**Re: Massey Warehouse-Phase 2
8410 Washington St.
Grading and Drainage Plan
Engineer's Stamp dated: 11/22/2016 (C17D003)**

From: Carrillo, Abiel X.
Sent: Wednesday, November 02, 2016 4:44 PM
To: D. Mark Goodwin (mark@goodwinengineers.com)
Subject: Massey - Phase 2 - C17D003 - Stamp Date 10-10-2016

**Re: Massey Warehouse
Massey - Phase 2 - C17D003 - Stamp Date 10-10-2016**

### MASSEY - PHASE 2 GRADING & DRAINAGE AND UTILITY PLAN

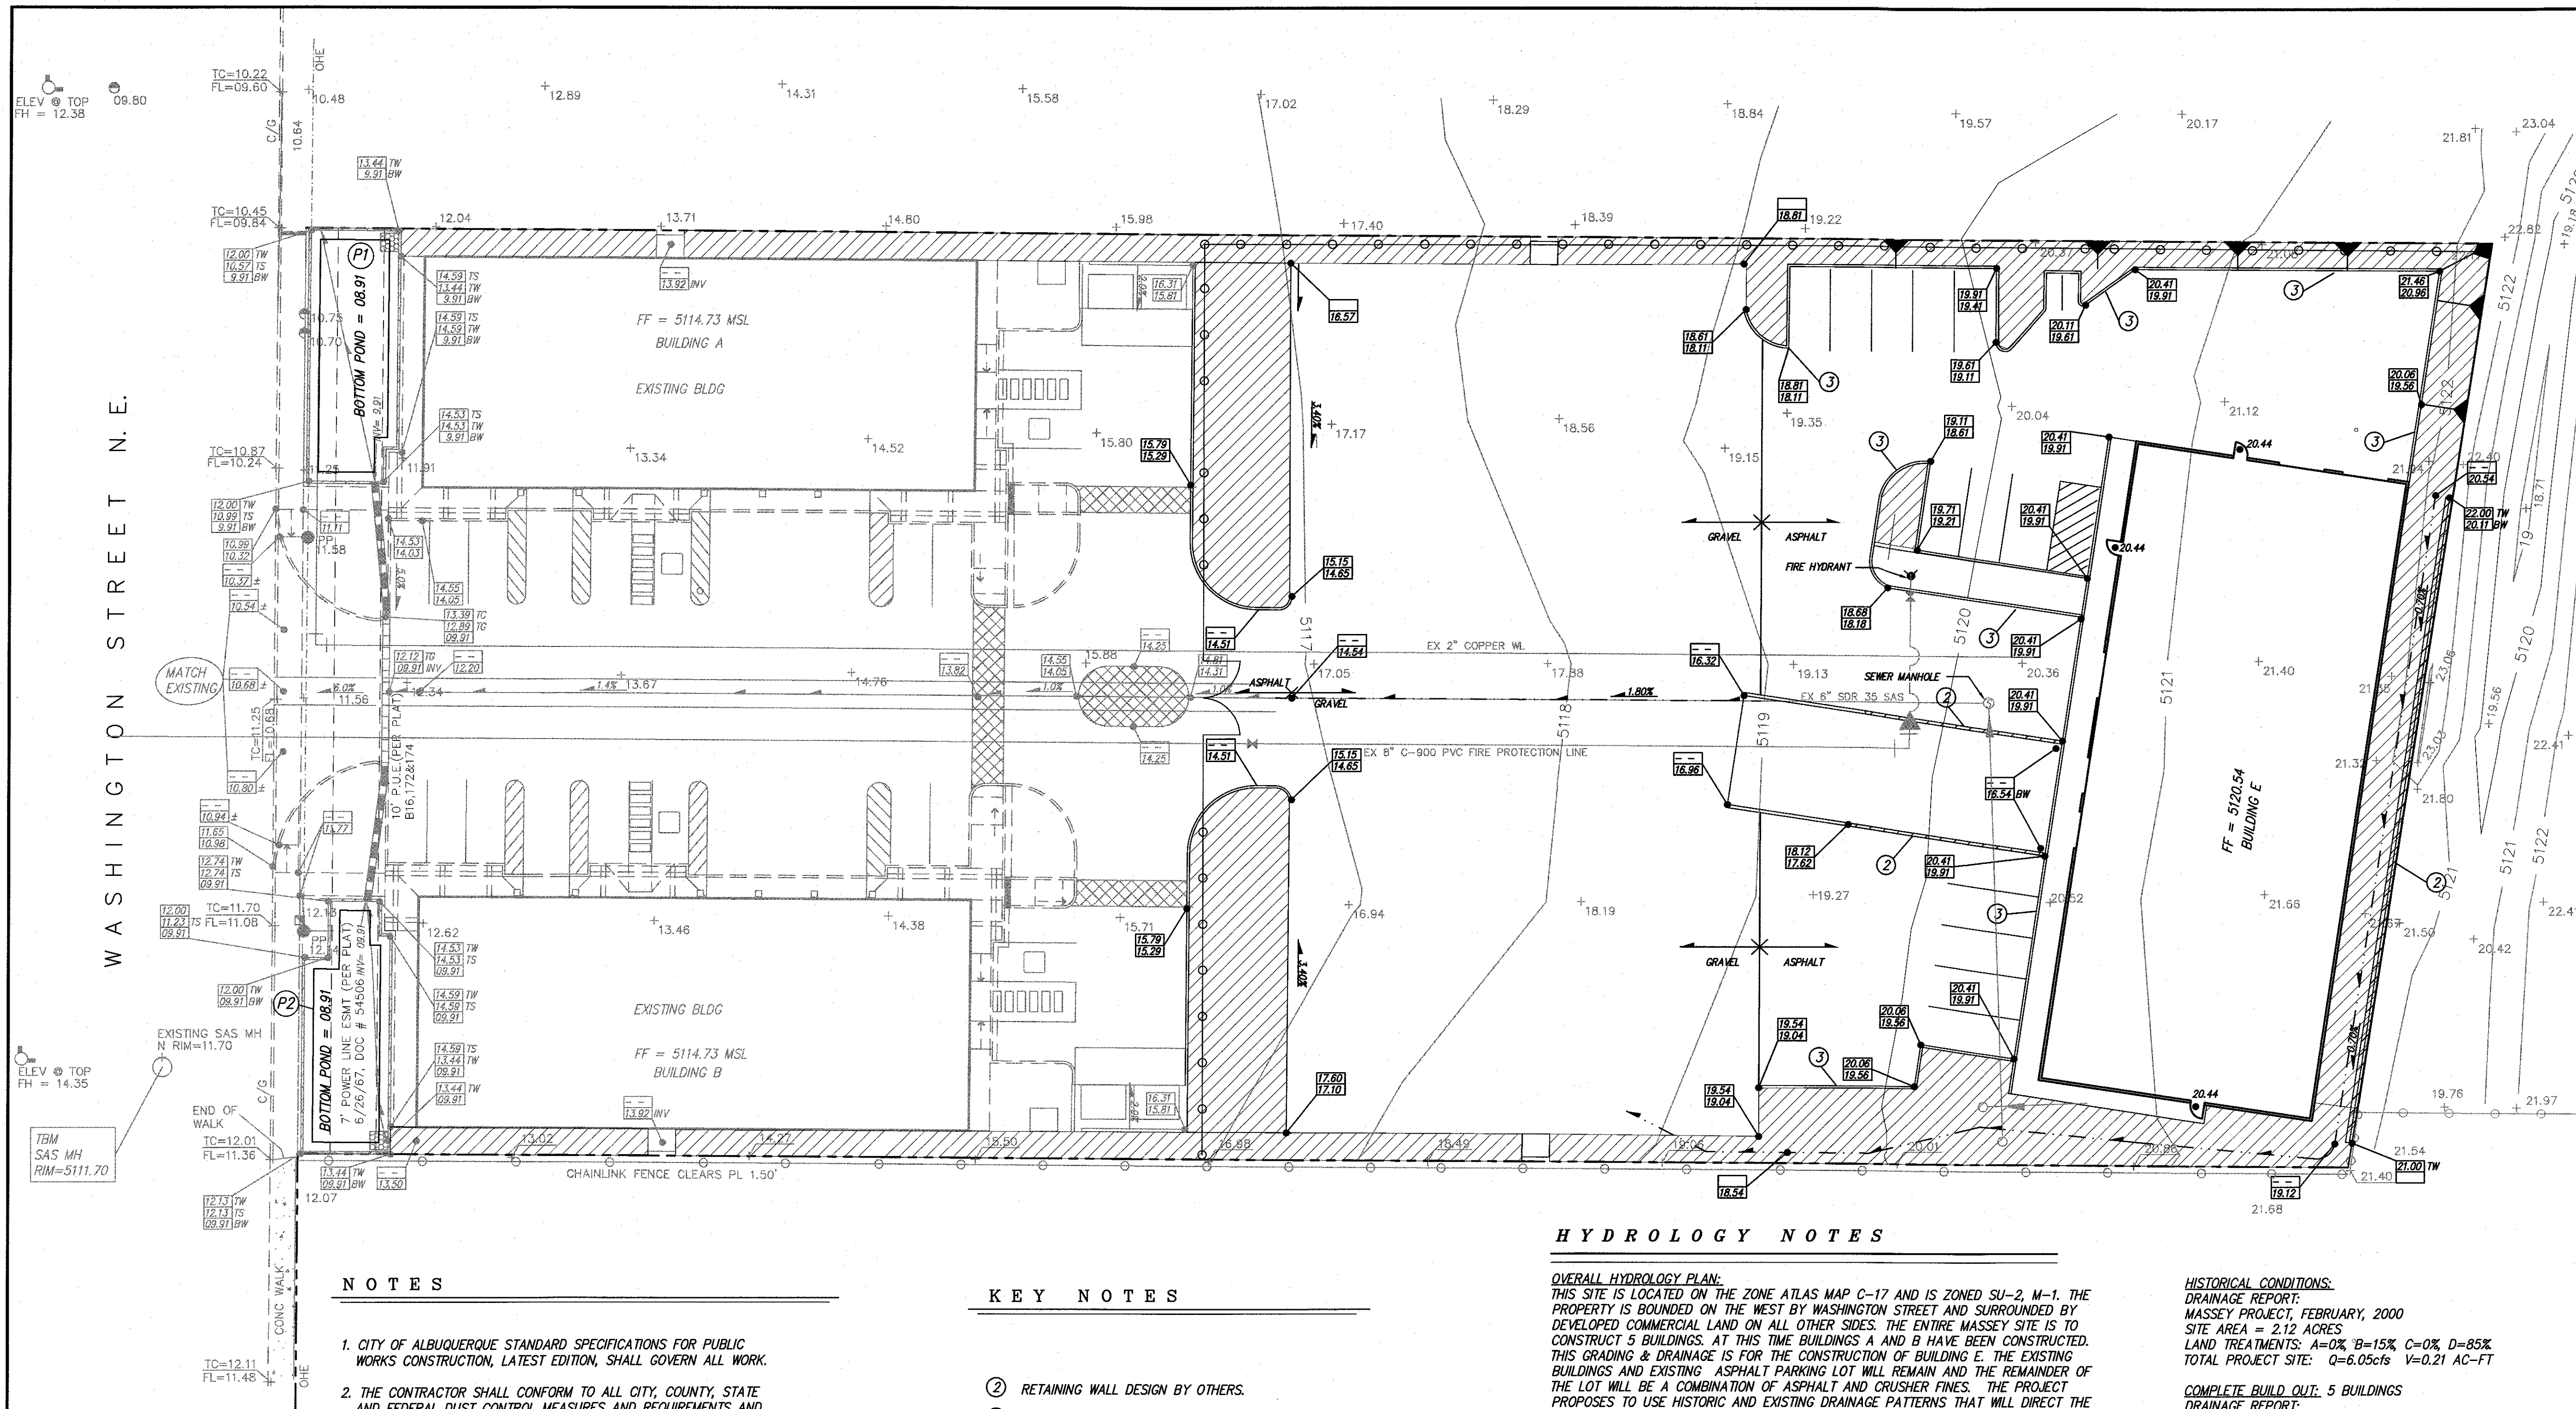
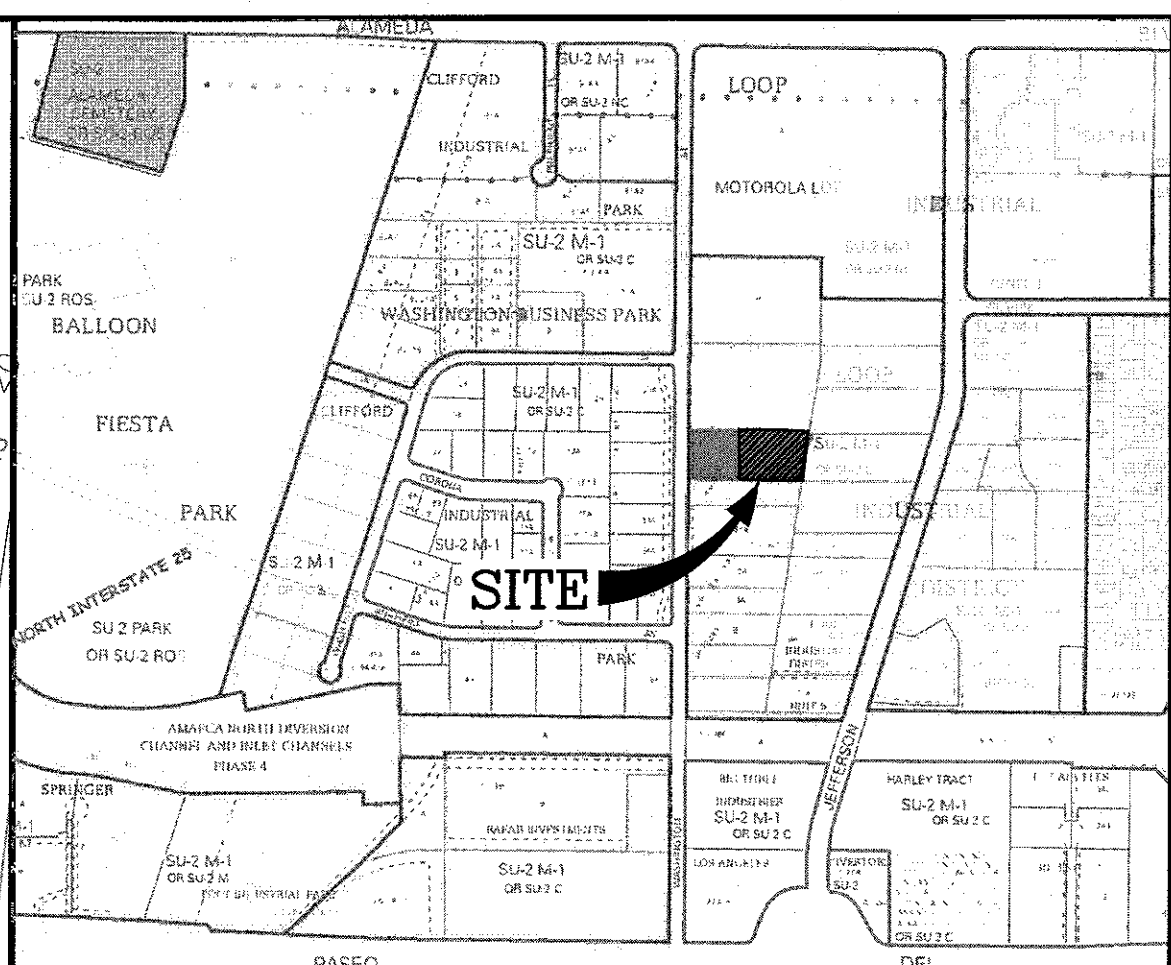
1. The Hydrology Notes mention that the pond ~~at~~⁺ the west end of the site will have enough volume to manage the first flush volume. The volume required needs to be shown on the plan, since the masterplan is dated prior to the date of the first flush ordinance.

- a. The pond does not appear to be designed to retain any volume; the outfall invert is set at the same elevation as the pond bottom.
2. Place rip rap or other erosion control element upstream of the sidewalk piping along the southern swale to prevent clogging and conveyance to the adjacent property.

3. Will the site be graveled? Based on aerial photos it appears that the area between the Building E and the gate is a dirt lot used by a lot of trucks. A track pad (rip rapped pad) just inside of the gate should be considered to minimize sediment tracking onto the paved portion of the site (not a requirement, but may minimize maintenance of the ponds).

The pond bottom will be dug out with a 2:1 side slope and will retain the volume needed for the first flush. The revised grading plan shows a detail of the pond along with notes for the first flush and its volume needed.

With this iteration of the grading plan the sidewalk piping has been removed and is no longer needed. — Plan still shows it

The portion of the site between the proposed building parking lot and the existing fence will be graveled to allow for truck movement and minimize sediment tracking. Notation of the graveled area is noted on the revised Grading & Drainage plan.
